DRB Application No.: 05DRB-00114 (SBP)

Project Name: VIDAS SUBDIVISION

From: Elvira Lopez, Planner, Development Review

Subject: Project 1003646, Site Development Plan for Building Permit

**SITE & LANDSCAPE PLAN**  
 NORTH  
 AUGUST 12, 2004

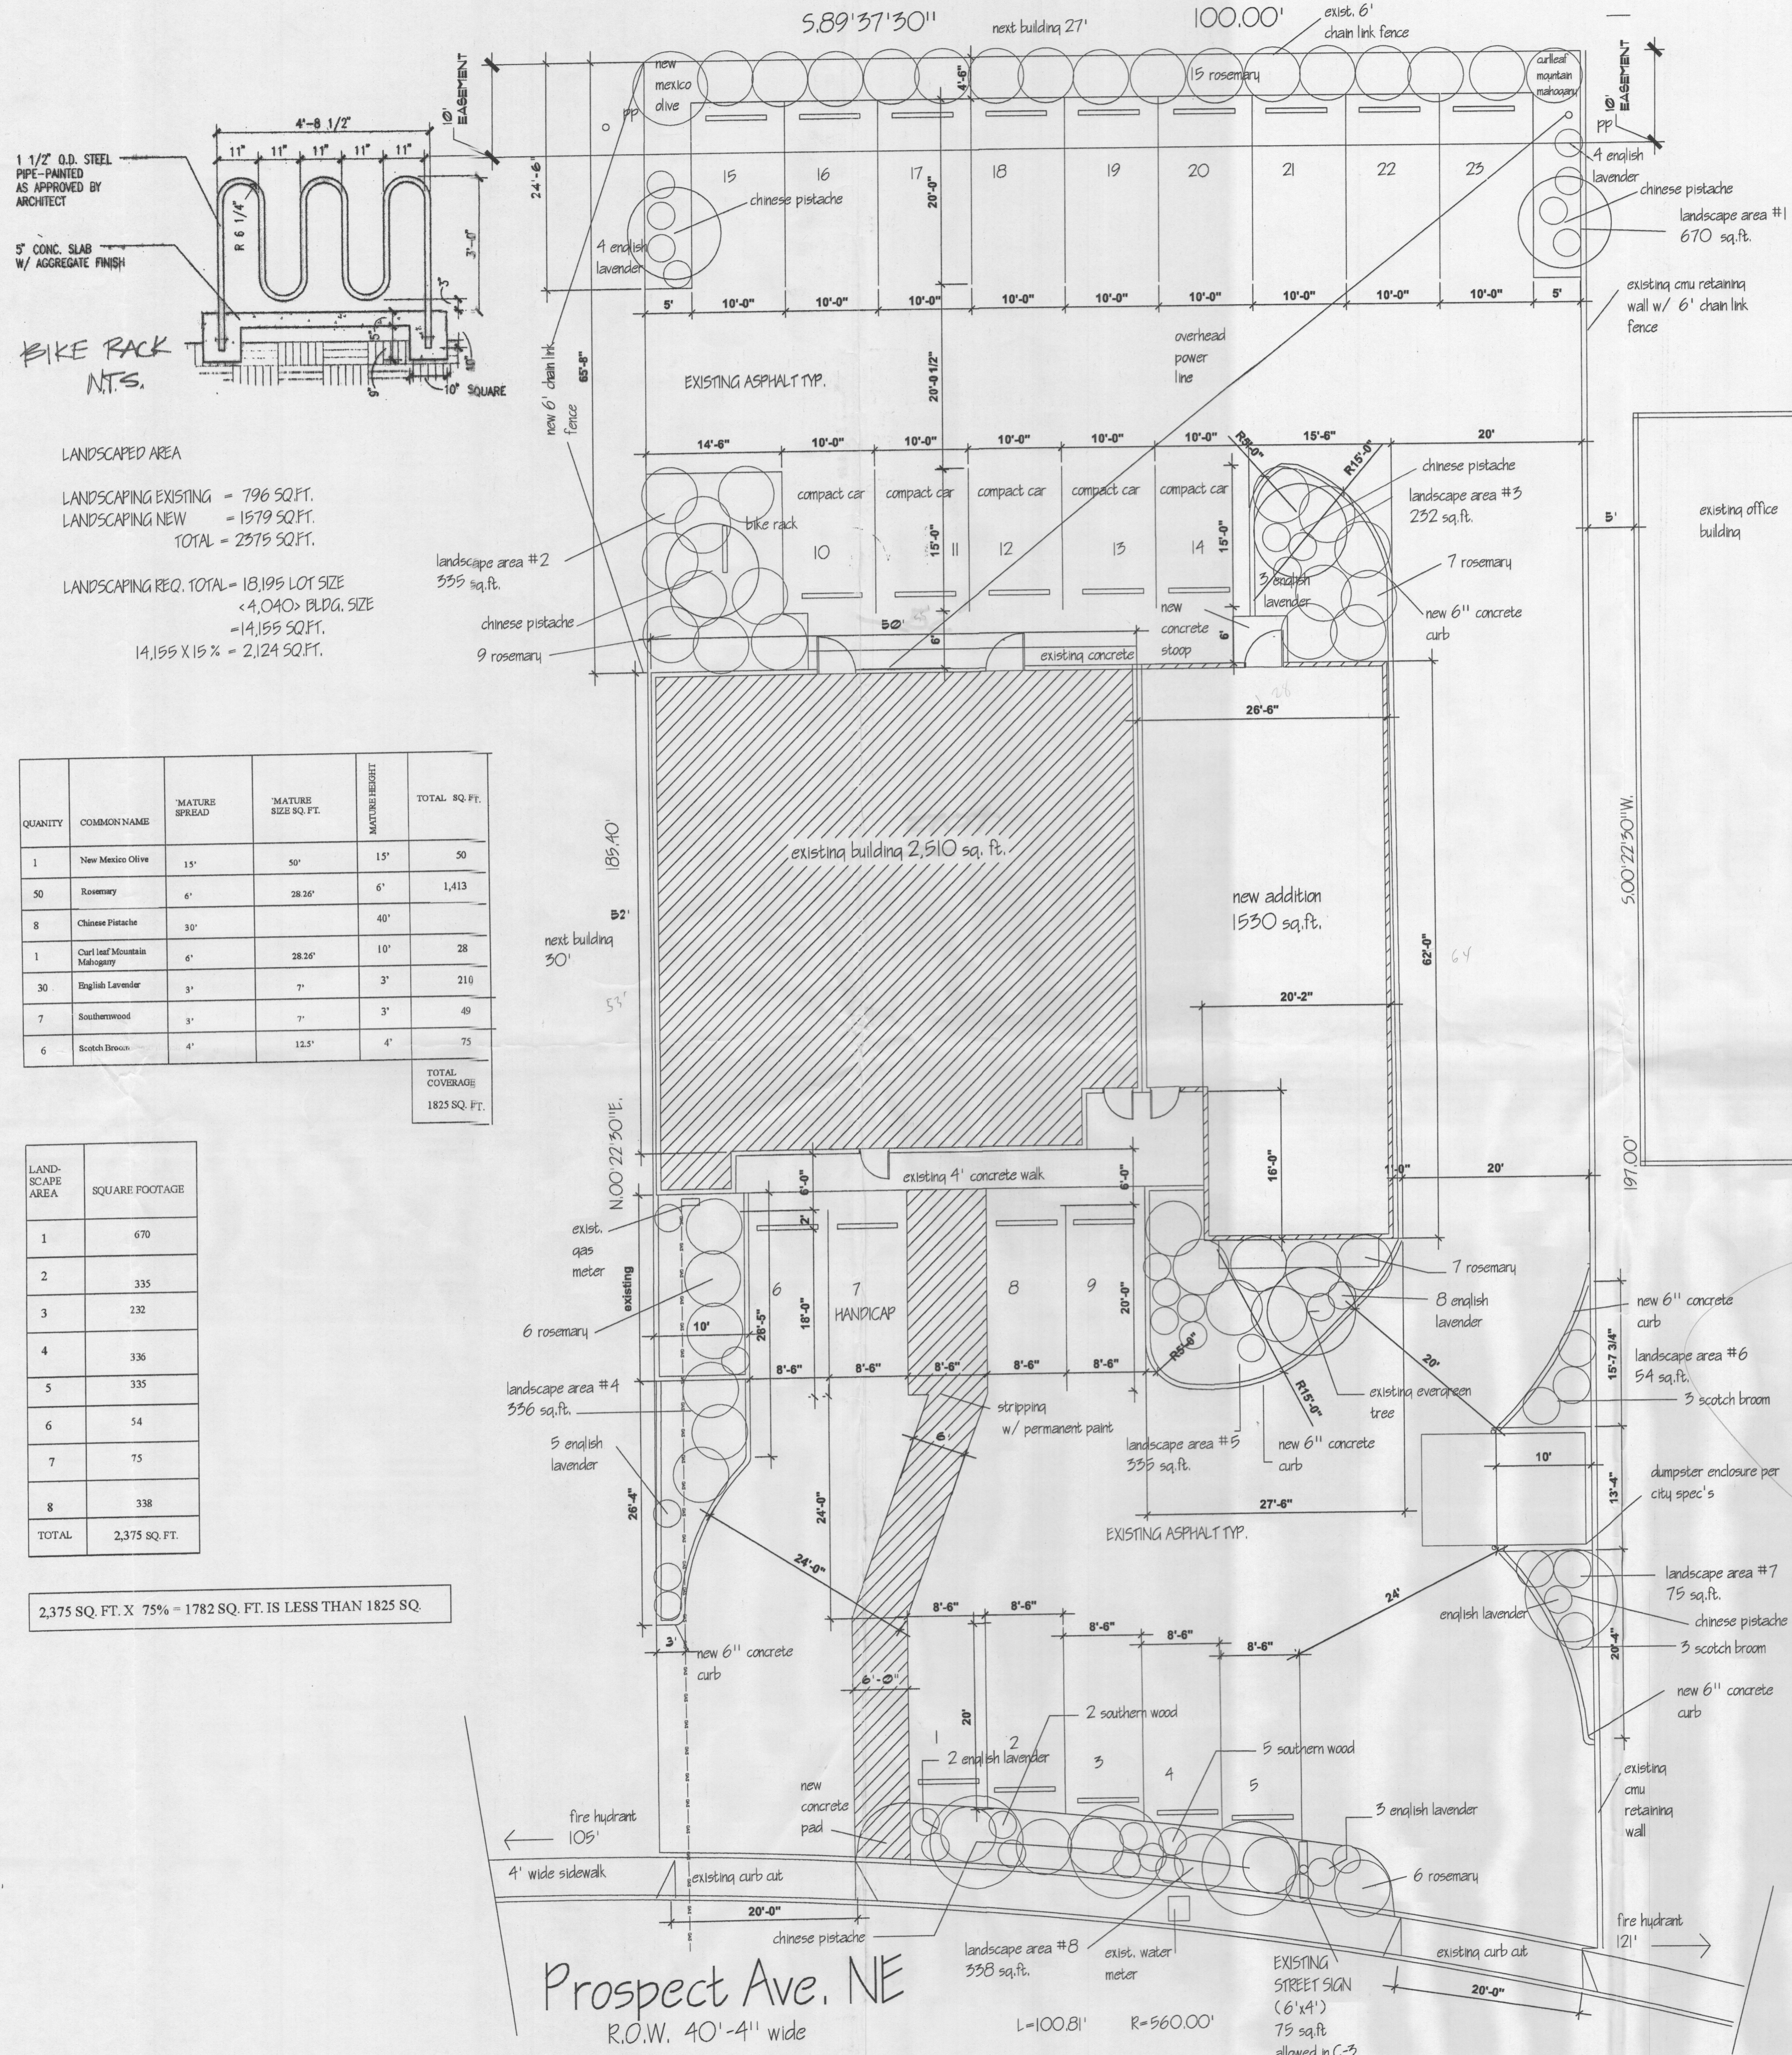
Condition 4: The bar scale indicates the plan is at a 1" equals 10" scale. Dimensions of the ~~building~~ building footprint do not appear to be consistent with this scale.

Condition 6: The right-of-way dimension is provided, but the pavement width is not indicated. At the time of EPC review, staff believed that the 40'-4" wide dimension that was provided then was the pavement width of the road. Please provide both the pavement width and verify that 40'-4" dimension is the right-of-way width.

Condition 7: It is unclear how the 6' wide pedestrian walkways function. These walkways are located along the south and north facades.

EXTERIOR ELEVATIONS

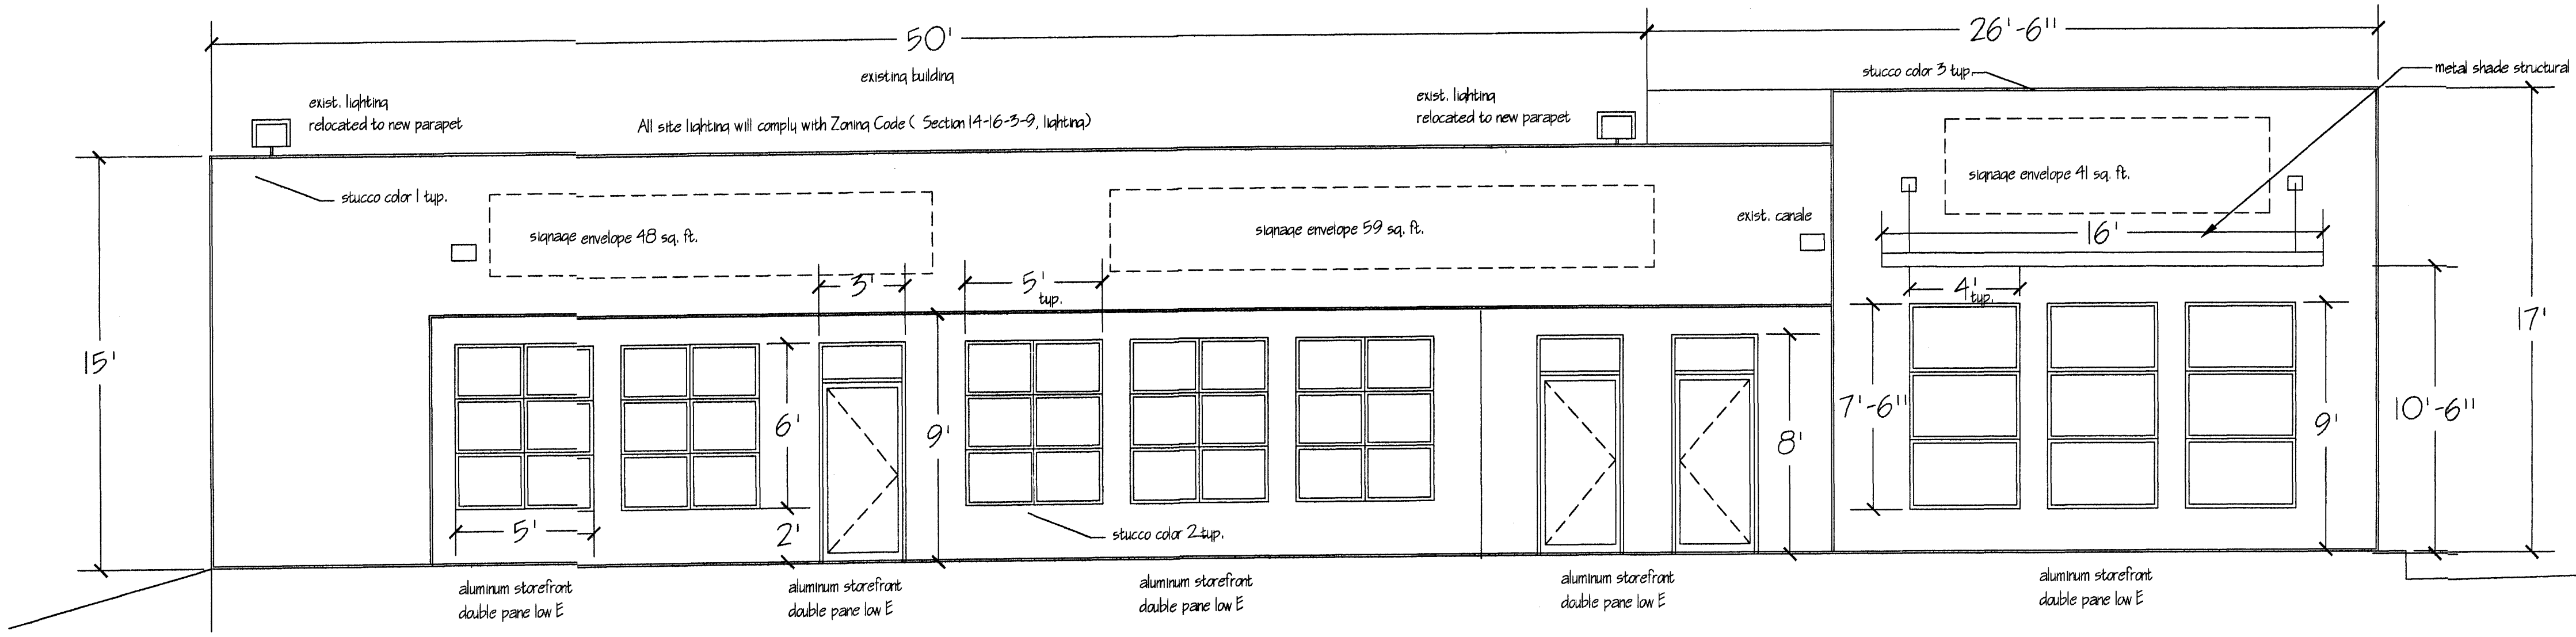
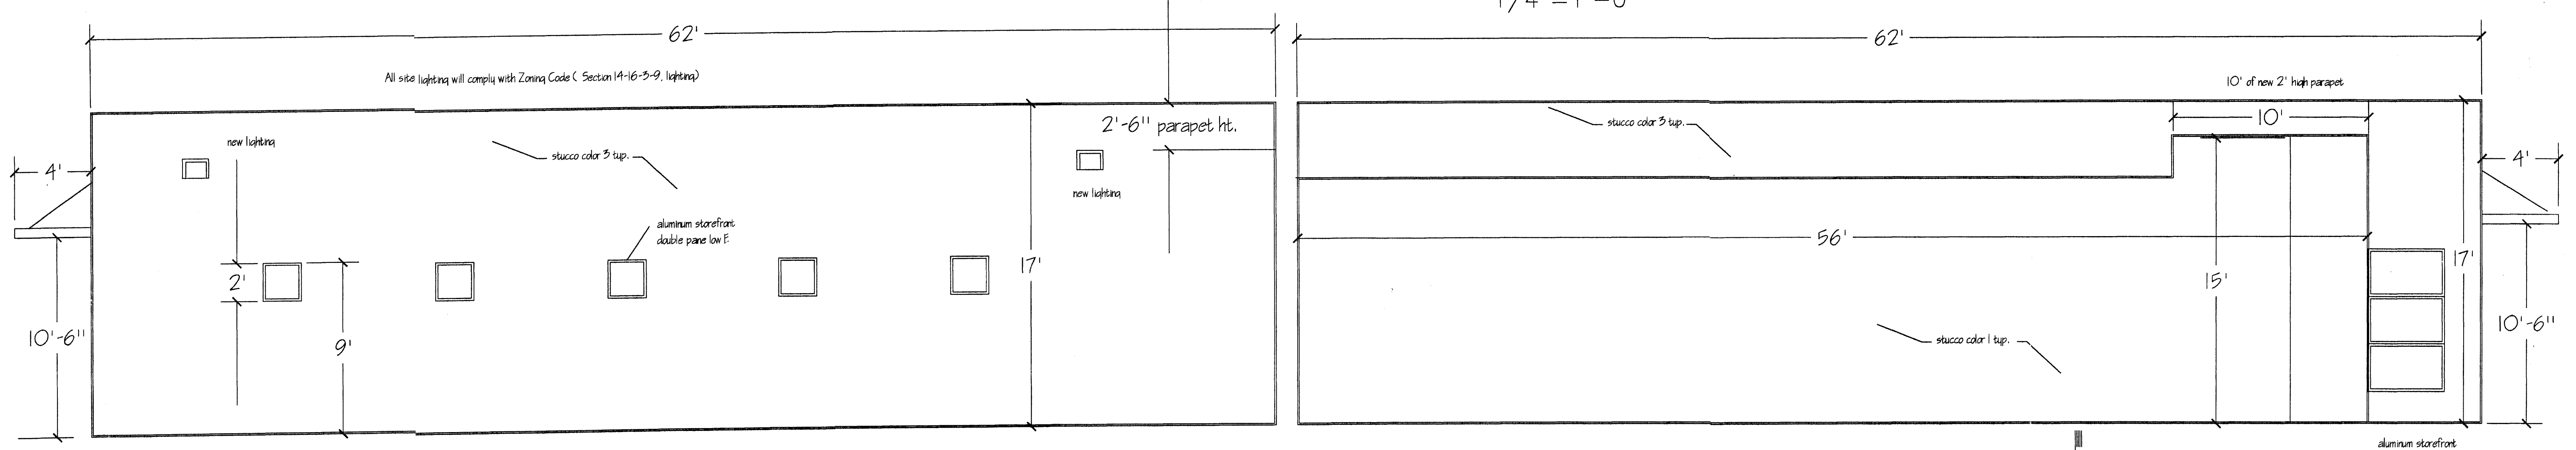
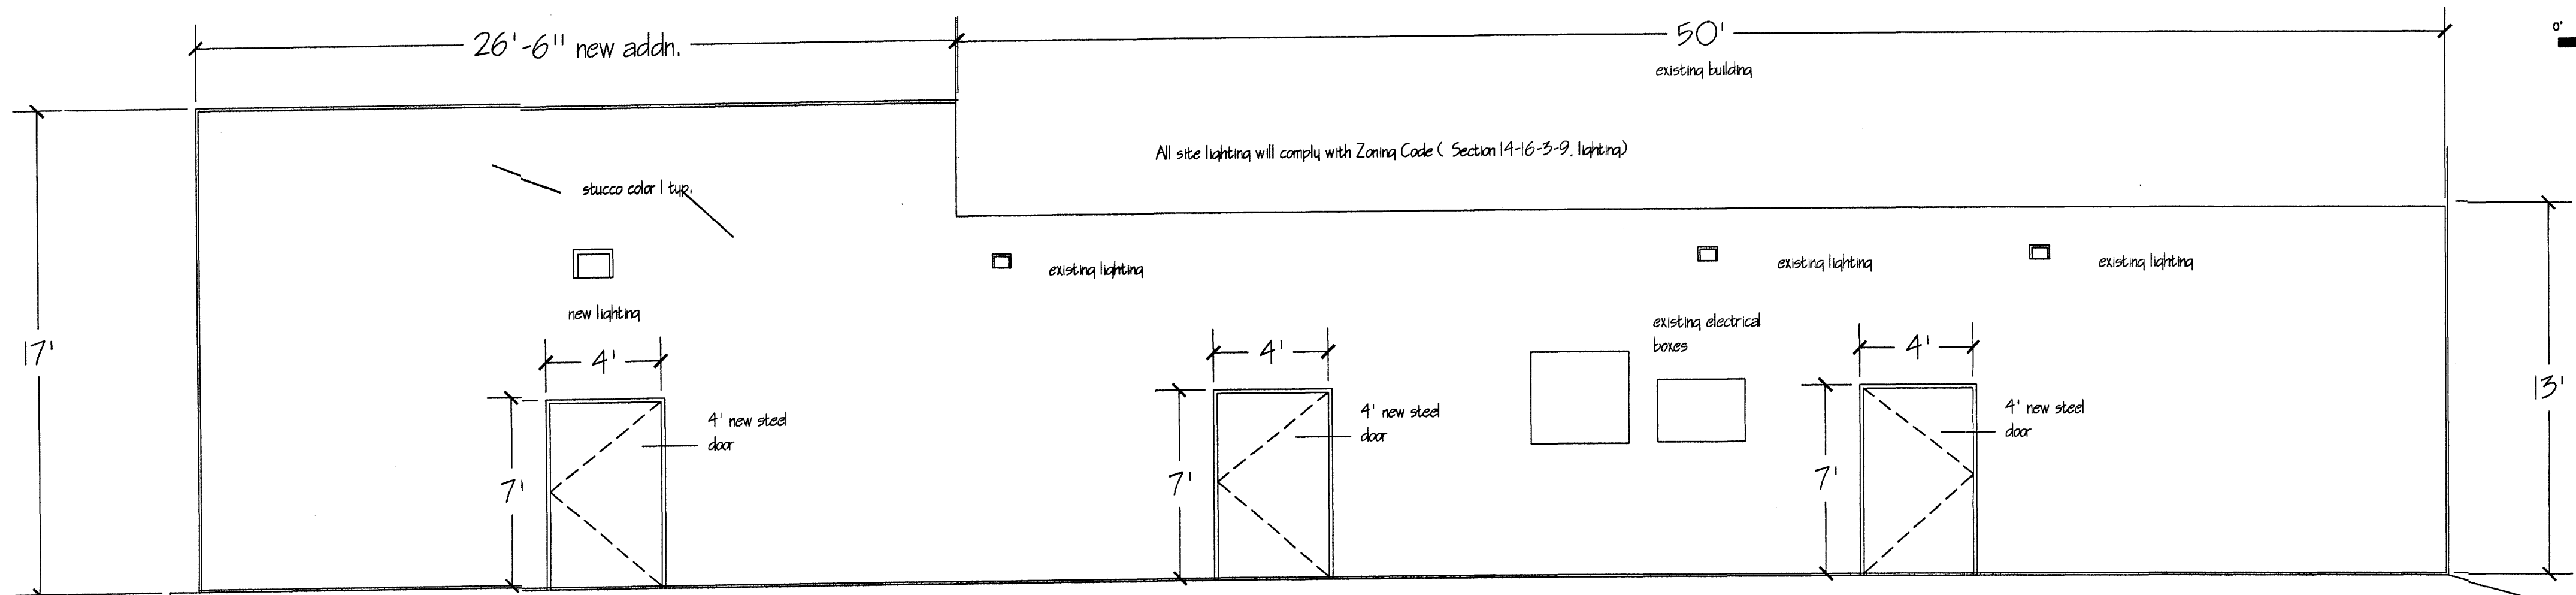
Condition 3: Notes regarding the free-standing sign are consistent with the C-3 zone. However, contrary to the applicant letter to the DRB, the building mounted signage is limited to ½ of 20% of the front façade according to Section 14-16-2-17 (9)(c)(2)(b). In this case, the building mounted signage cannot be more than 10% of the front façade. The current submittal proposes building mounted signage greater than 10% of the front façade. The elevation drawings should indicate the building mounted signage as a percentage of the front façade.
